Re: Wind farm development of 20 turbines with 110kV electrical substation and all related site works and ancillary development.
Townlands of Annagannihy, Aughinida, Ballynagree East, Ballynagree West, Bawnmore, Caherbaroul, Carrigagulla, Carrigduff, Clonavrick, Derryroe, Drishane More, Dromagh, Drominahilla, Dromskehy and other townlands, Co. Cork.

OPW Ref: 37-2022
Your Ref: PA04.312606

The Proposed Ballinagree Wind Farm, Co. Cork

Directional Drilling Bridge Crossing Detail - Longitudinal Section

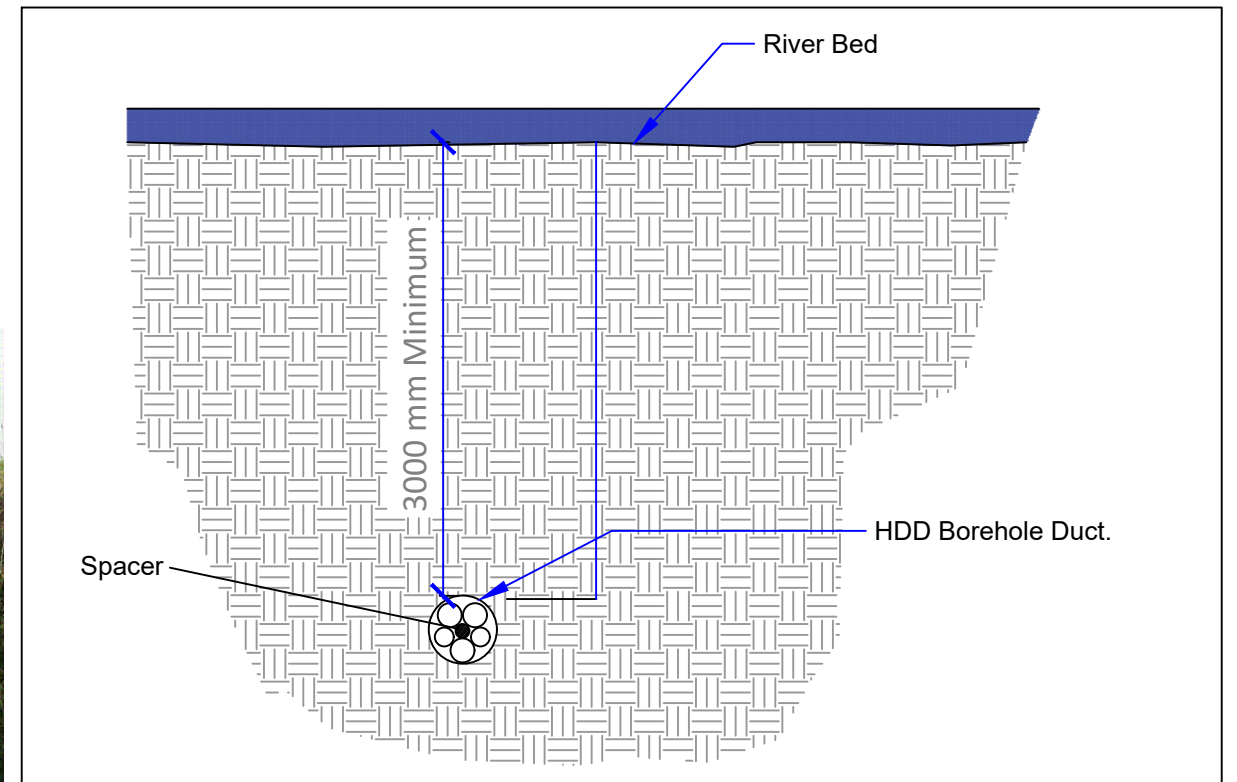
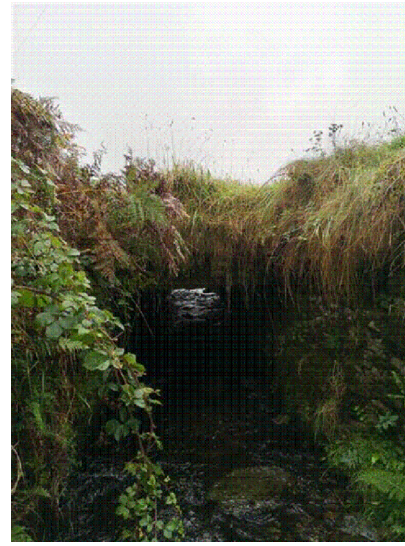
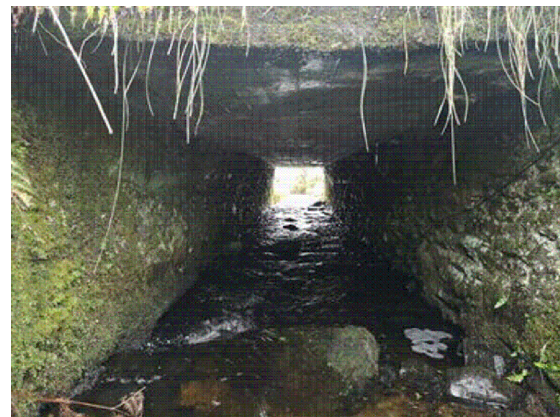
- (v) If the cable and ducting is to be buried under the natural bed of the watercourses being crossed, (as indicated on Sheet Number 05843-DR-019 '*Horizontal Directional Drilling Culvert Crossing Detail*') Section 50 would not apply. In this circumstance we would recommend that the duct be buried a sufficient distance below the natural bed to allow for erosion and mobility of the stream bed.
